Subject: RE: Planning Consultation on: AL/27/20/PL

Engineers Comments Regarding Surface Water Drainage

Registered: 20th April
2020
Site Address: Springfield Hook Lane Aldingbourne PO20 3TE
Grid Reference: 493480 104546

Description of Works: Demolition of the existing dwelling & construction of 2 No. 2-bed, 3 No. 3-bed & 4 No. 4 bed houses including access, landscaping & associated works (resubmission following AL/51/19/PL).

Proposed Block Plan 1:500@A3

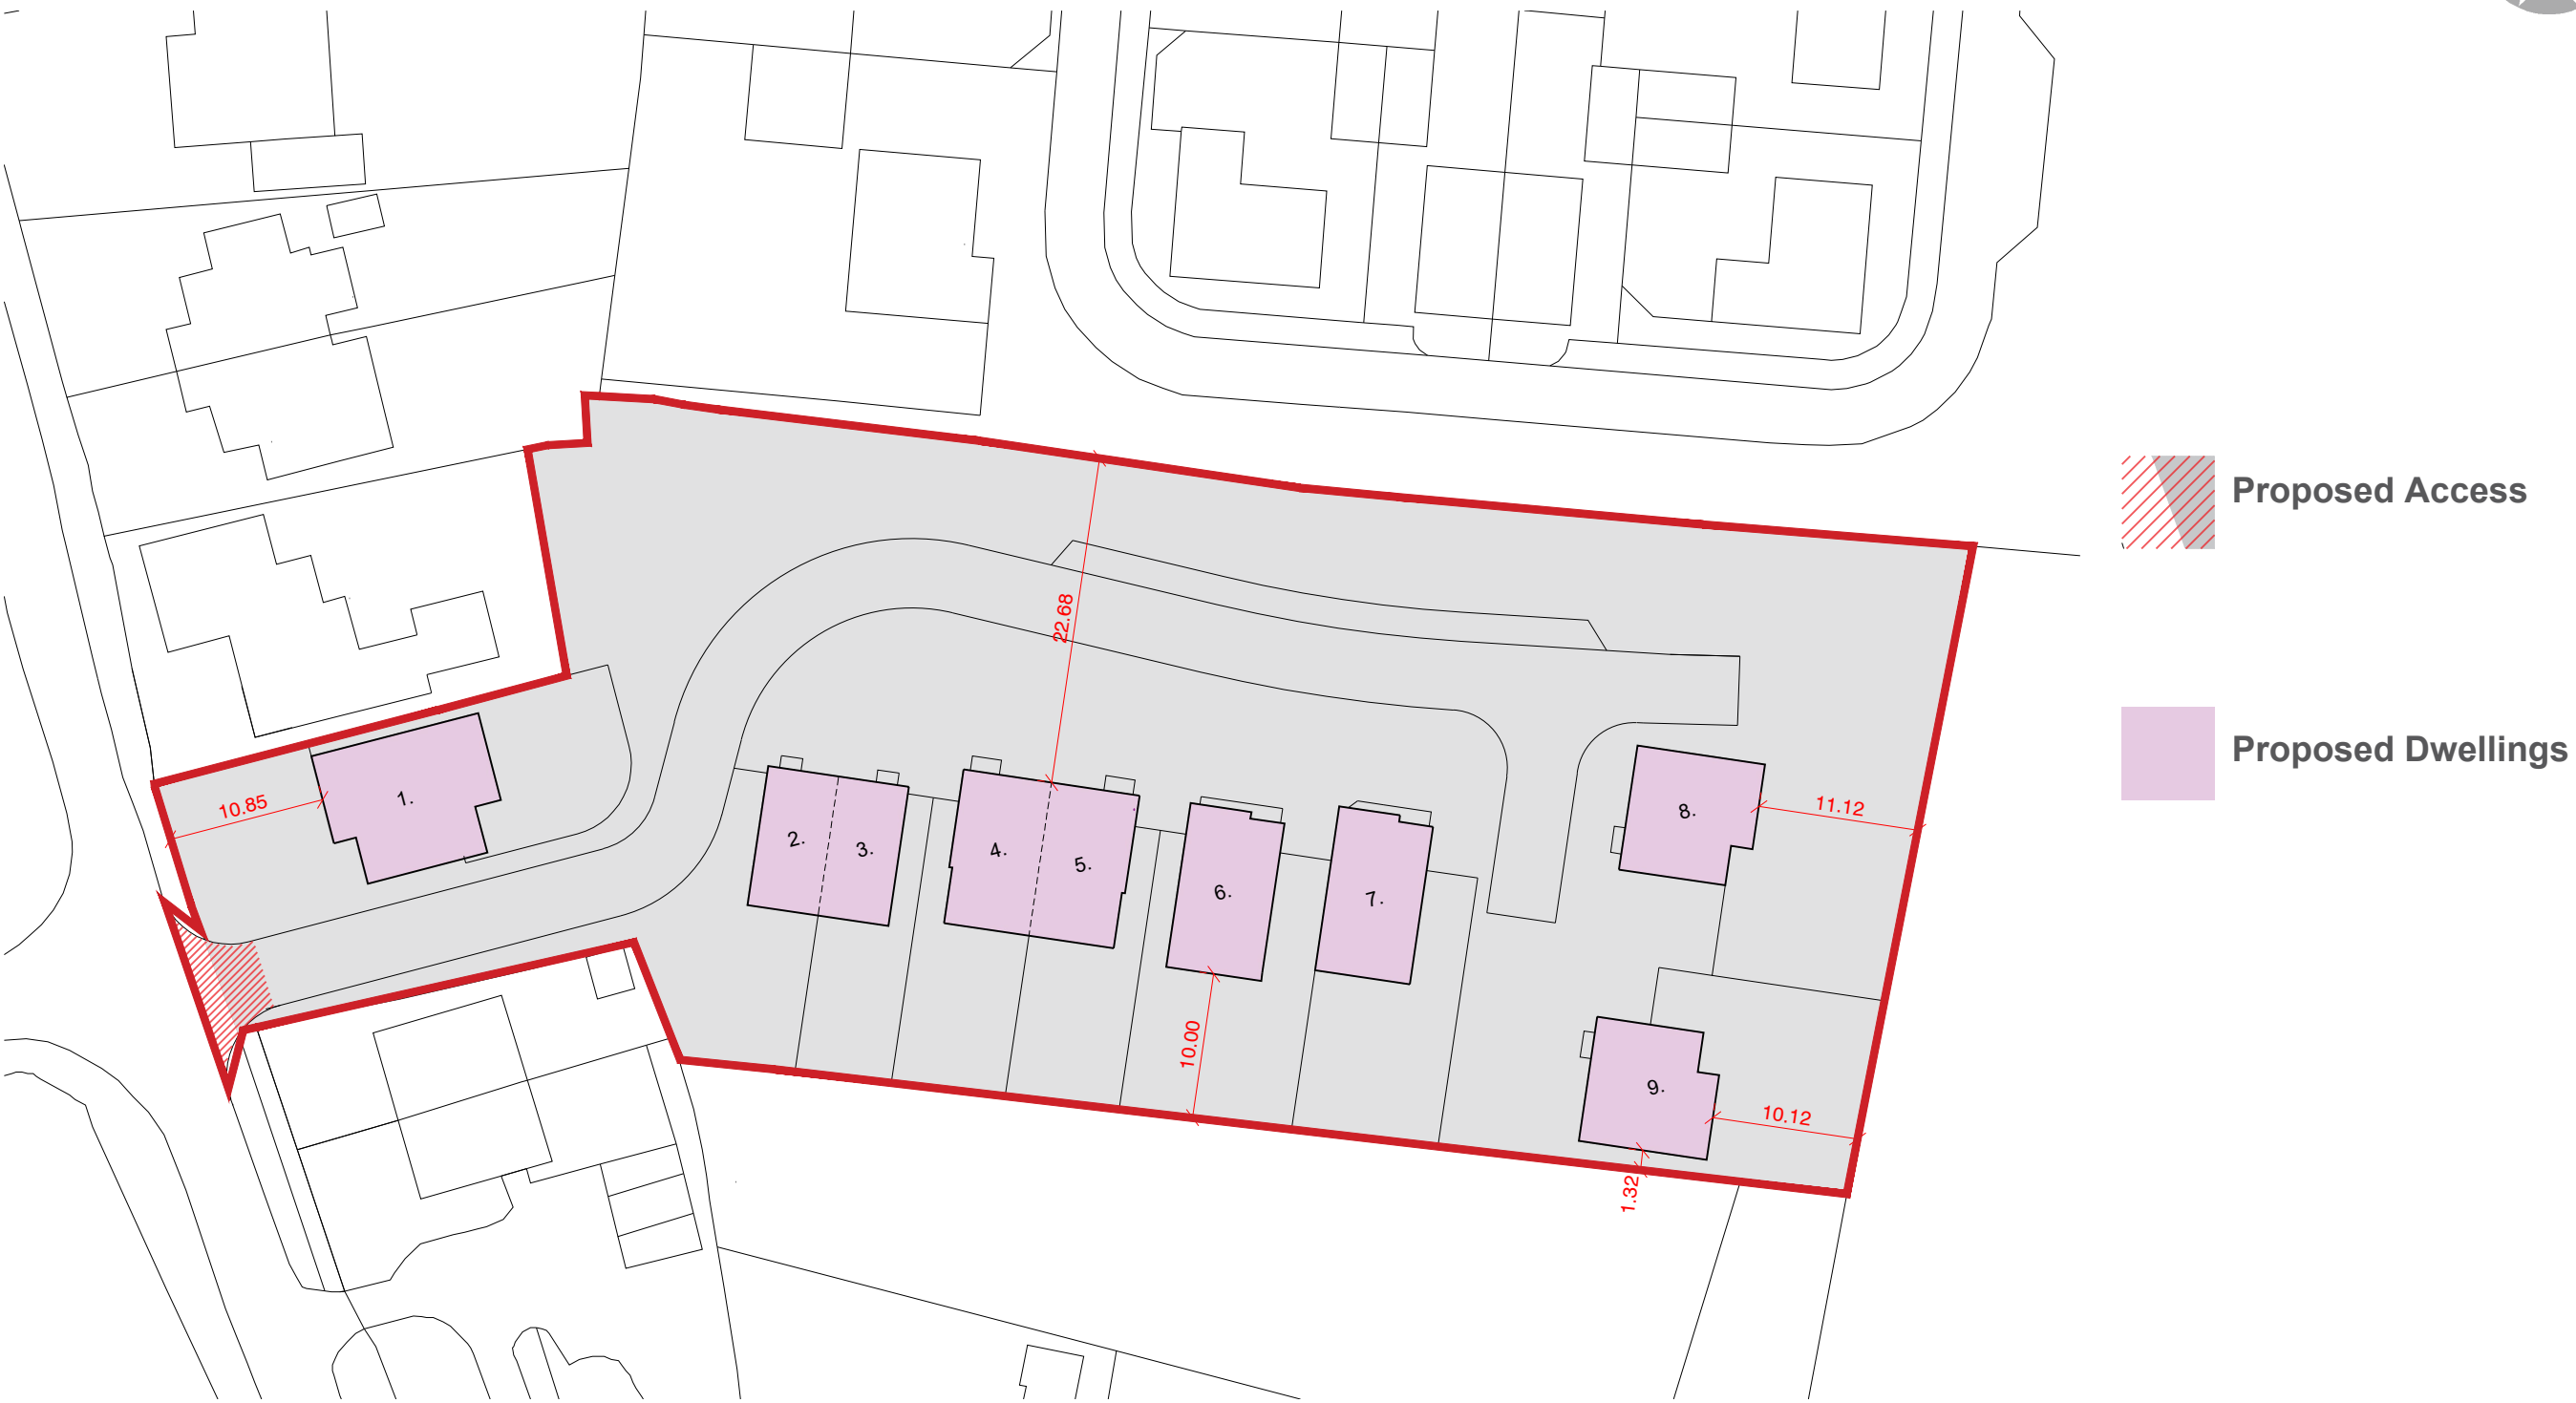
7. The applicant is reminded that all houses, fences and walls must be kept at least 3m from the top of the bank of the watercourse on the northern boundary of the site.
